Revision E - Section 75W Amendments.
1 Four spaces have been converted to two disabled spaces to accommodate increase in total adaptable apartments numbers (additional 2, from 59 to 61)

Site 3
Sydney Olympic Park
Plan
Basement 001

Revision E - Section 75W Amendments.

Site 3
 Sydney Olympic Park
 Plan
 Level 12

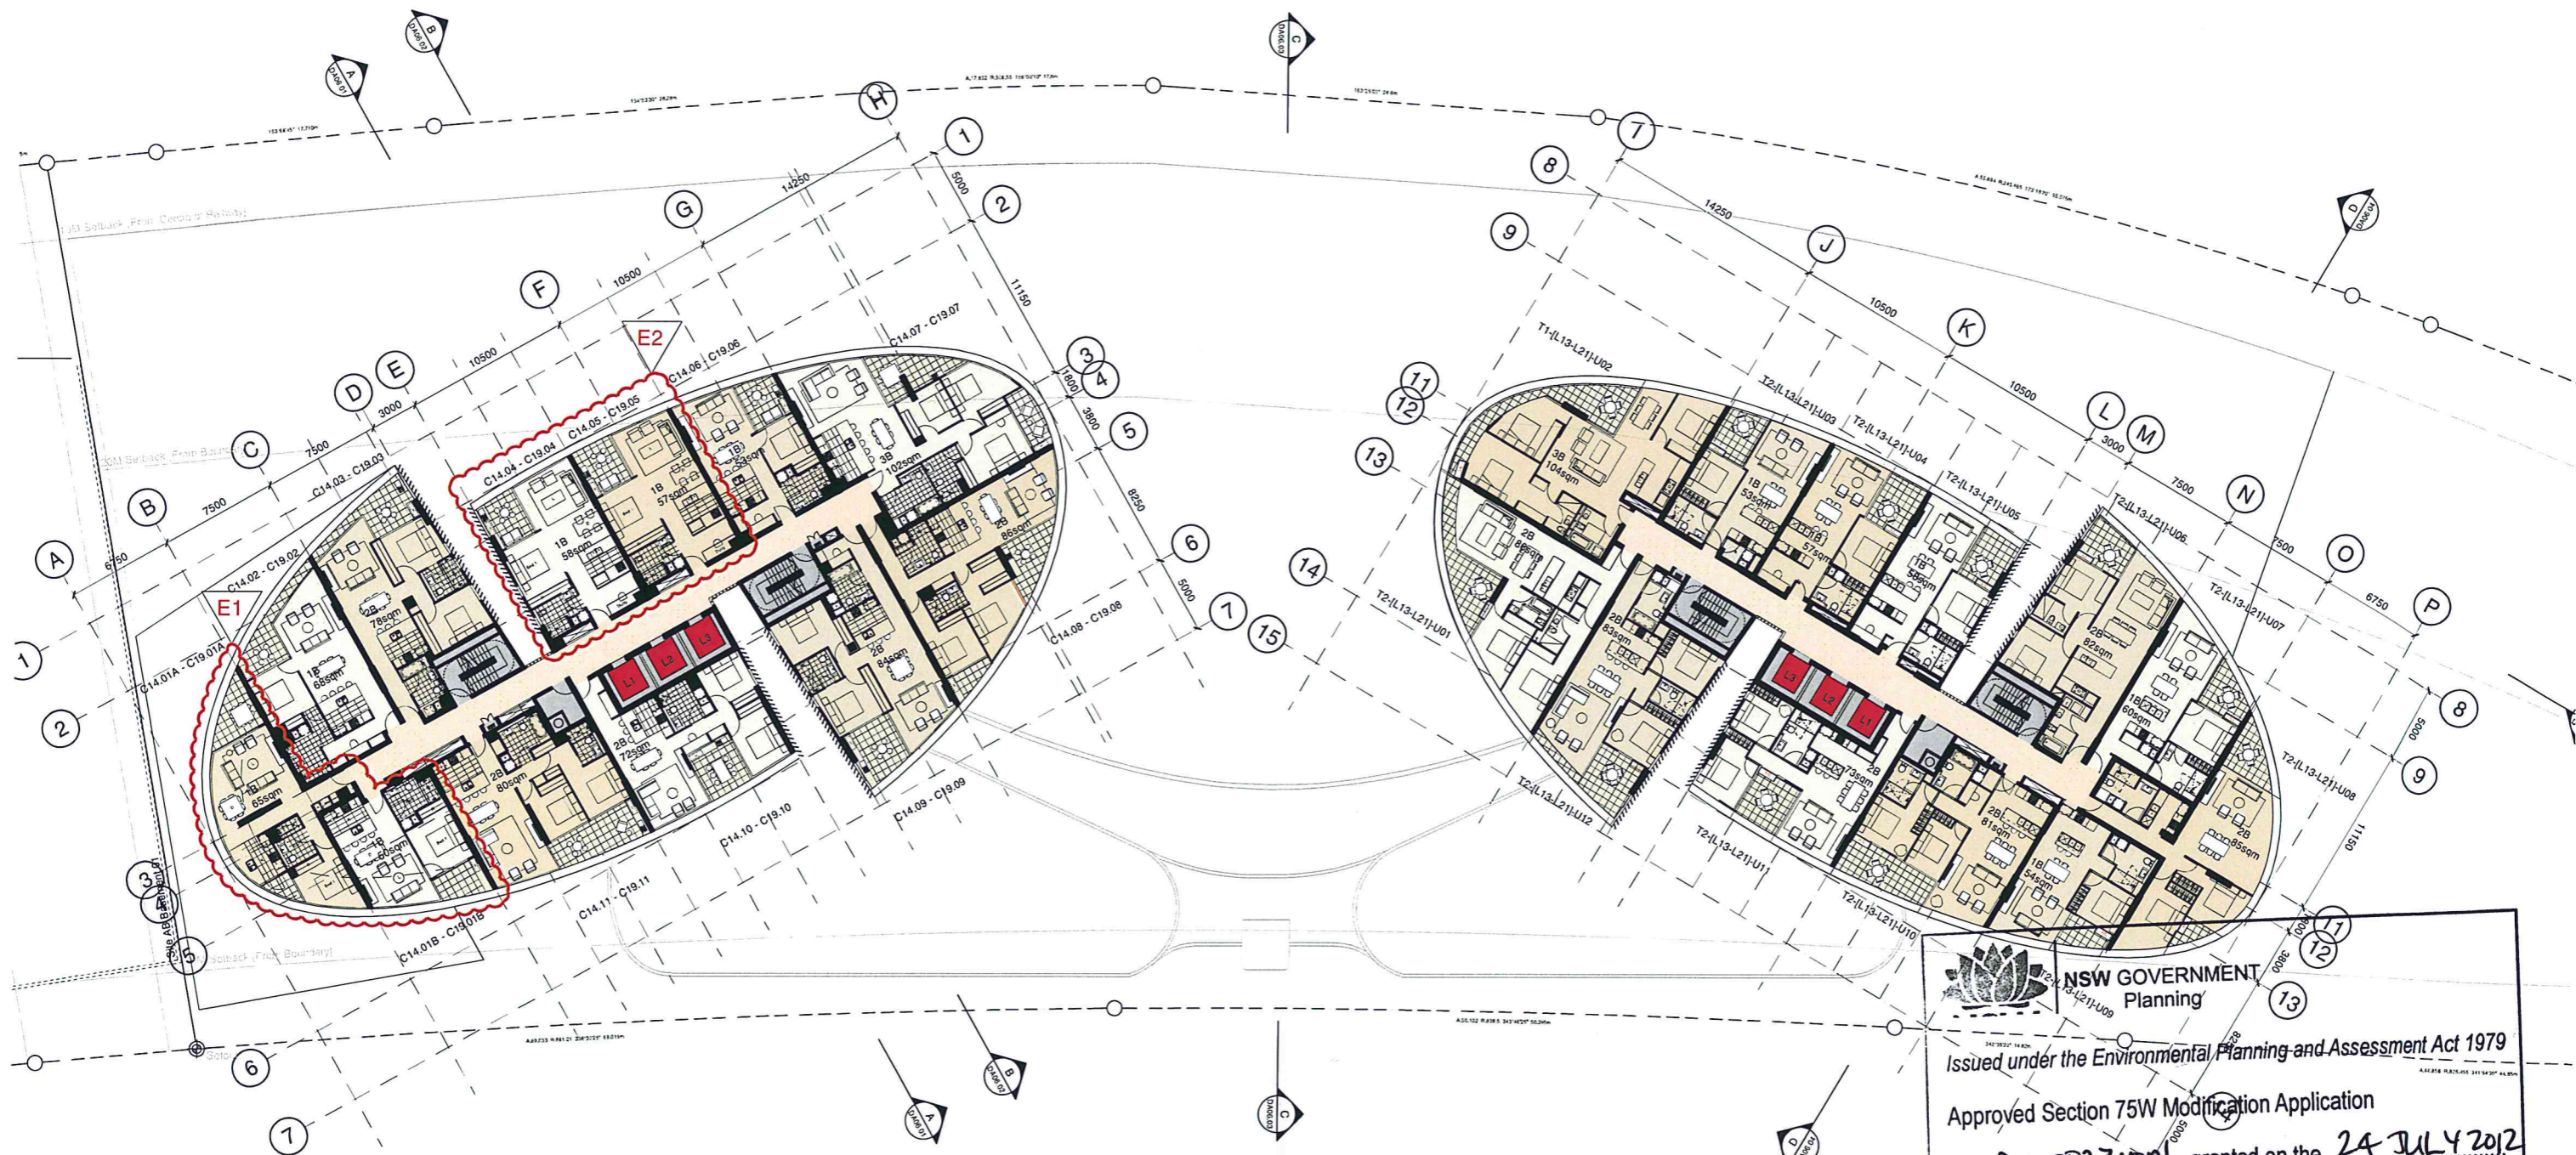
1. Change of apartment mix from one 3-Bed and one 2-Bed (C13.07 & C13.08) to one 1-Bed and one 3-Bed Dual Key (1-Bed+2-Bed) (C13.07 & C13.08).

2. Apartments C13.04 & C13.05 have been allocated as adaptable units.

Site 3
Sydney Olympic Park
Plan
Level 13-18

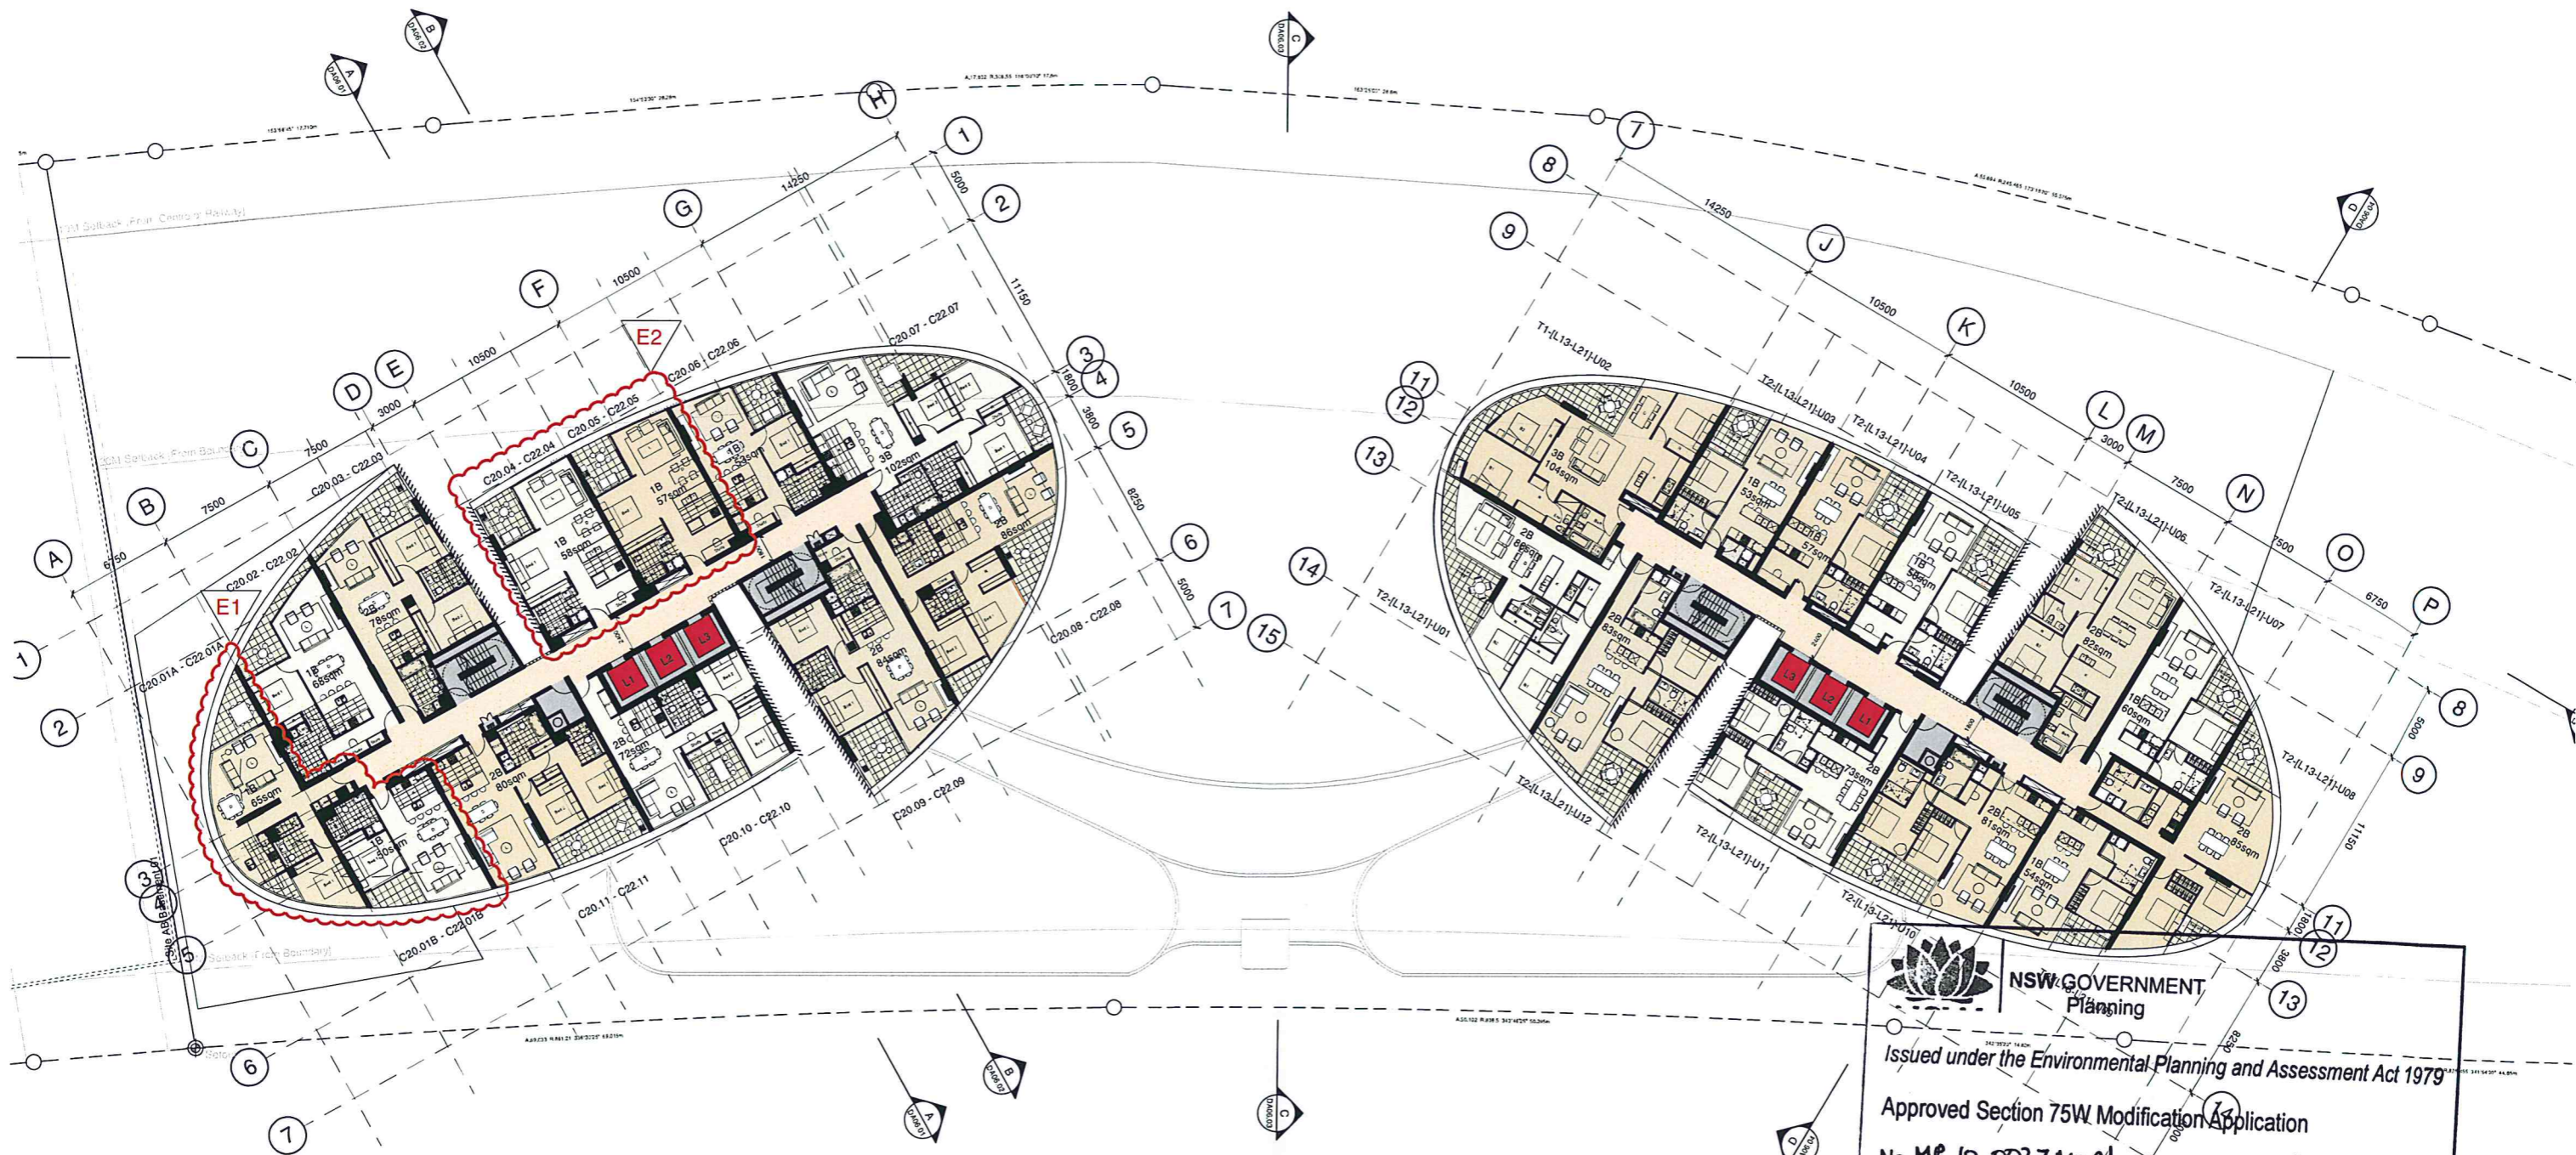
1. Change of apartment mix from one 3-Bed (C14.01-C22.01) to two 1-Bed (C14.01A-C22.01A & C14.01B-C22.01B).

2. Apartments C14.04-C22.04 & C14.05-C22.05 have been allocated as adaptable units.

Site 3
Sydney Olympic Park
Plan
Level 22

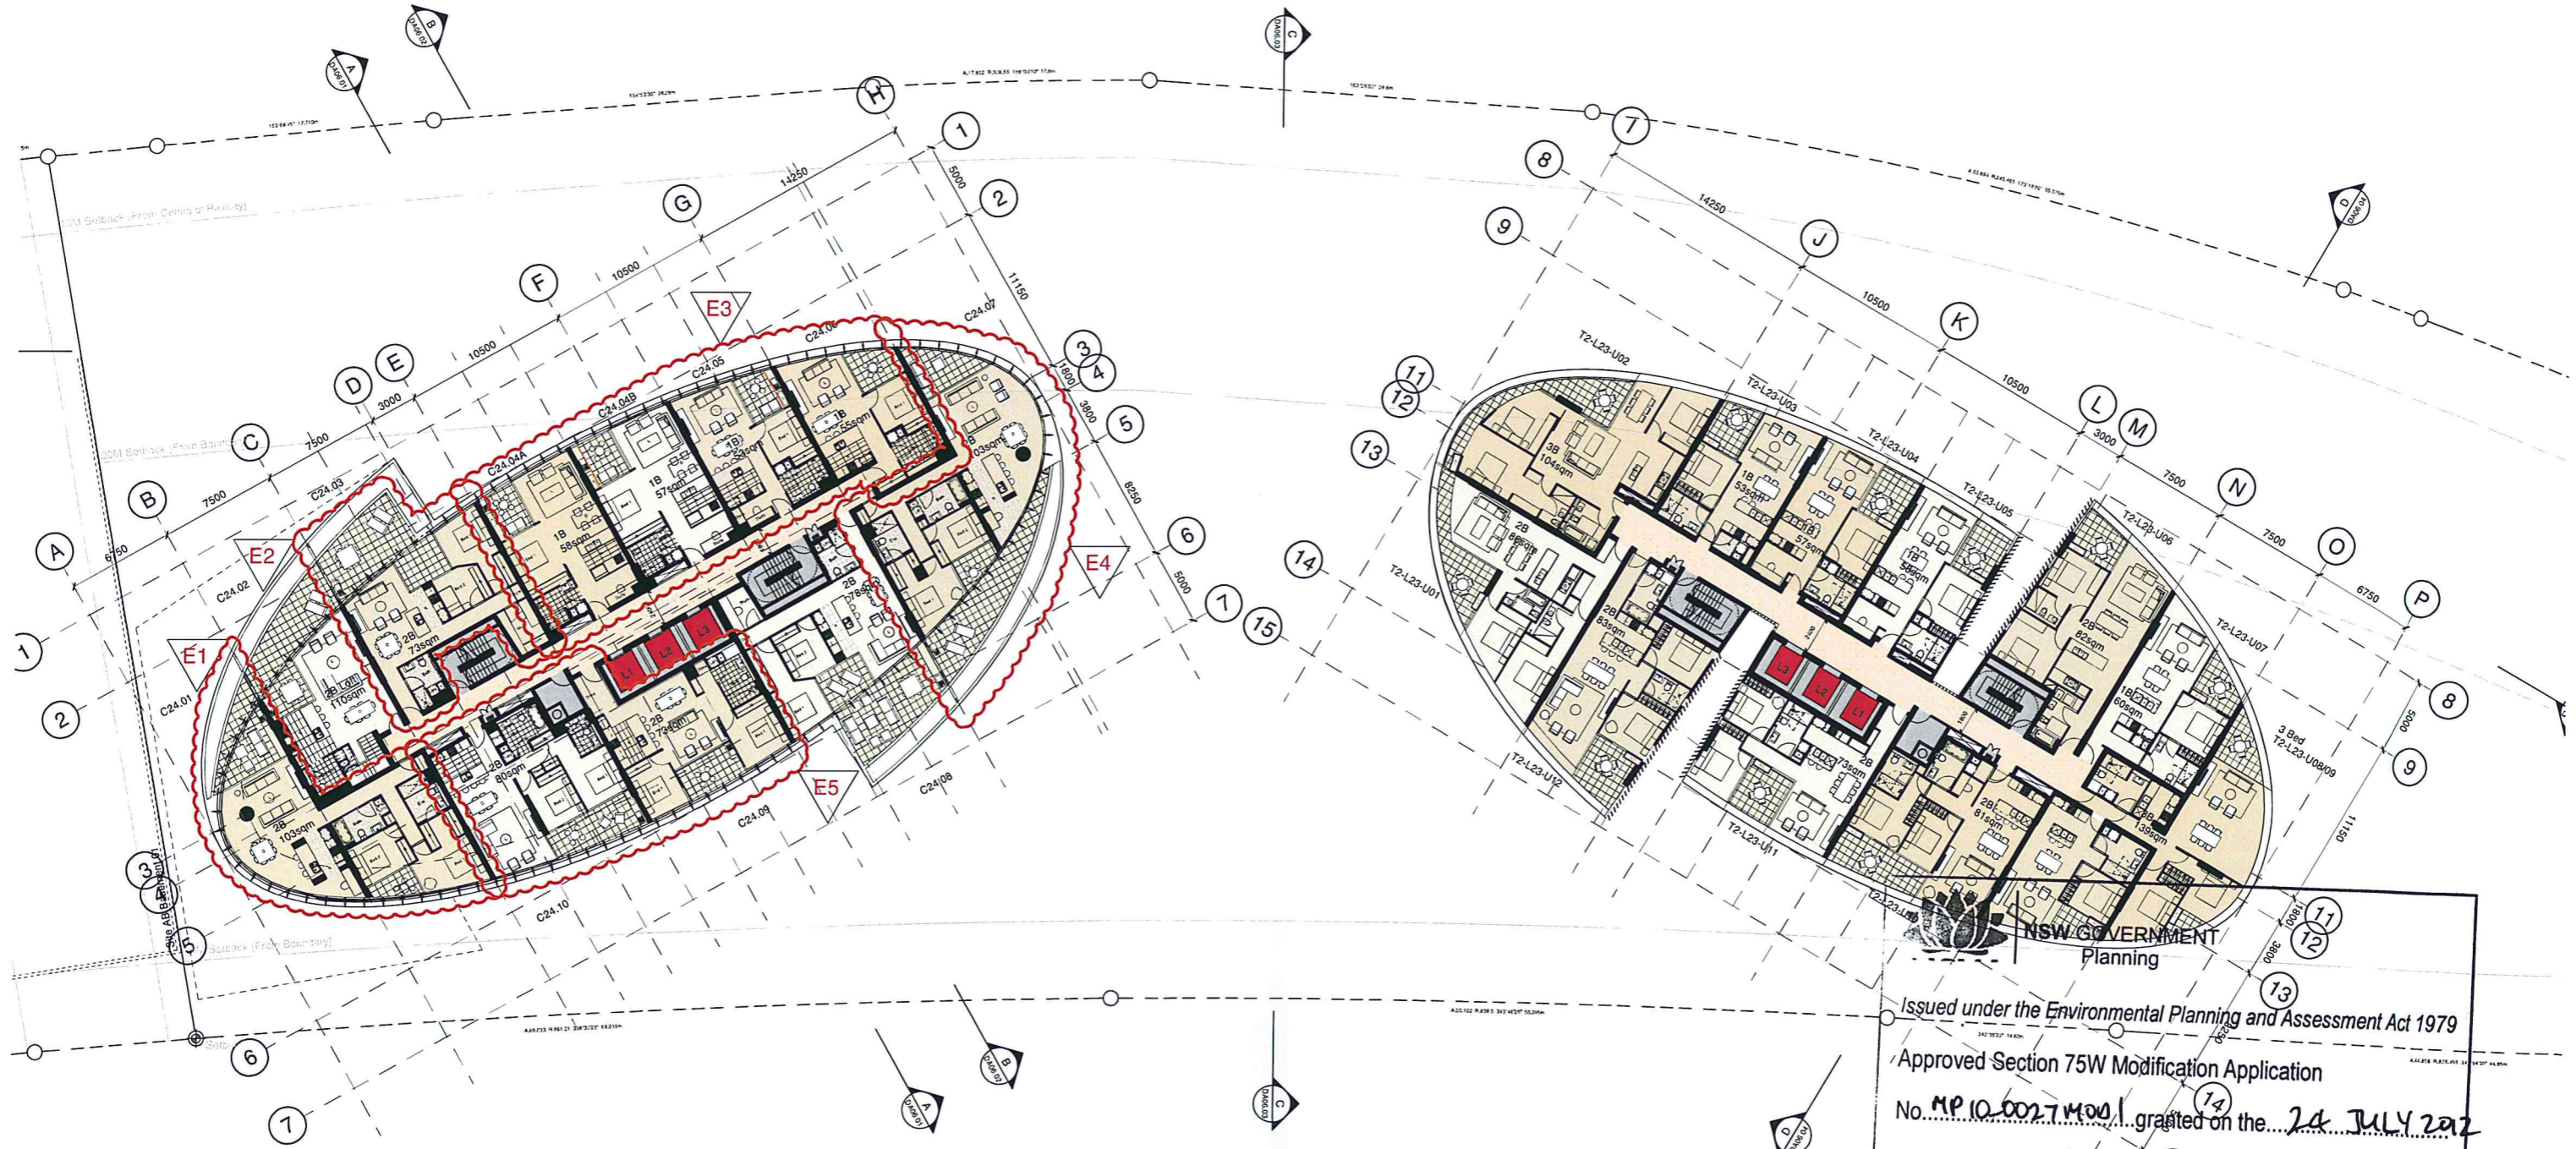
1. Change of apartment mix from one 3-Bed (C23.01) to two 1-Bed (C23.01A & C23.01B).
2. Change of apartment mix from one 3-Bed (C23.02) to one 1-Bed (C23.02A) and one 2-Bed (C23.02B).
3. Apartments C23.04 & C23.05 have been allocated as adaptable units.
4. Change of apartment mix from one 4-Bed (C23.06) to one 2-Bed (C23.06B) and one 3-Bed (C23.06A).
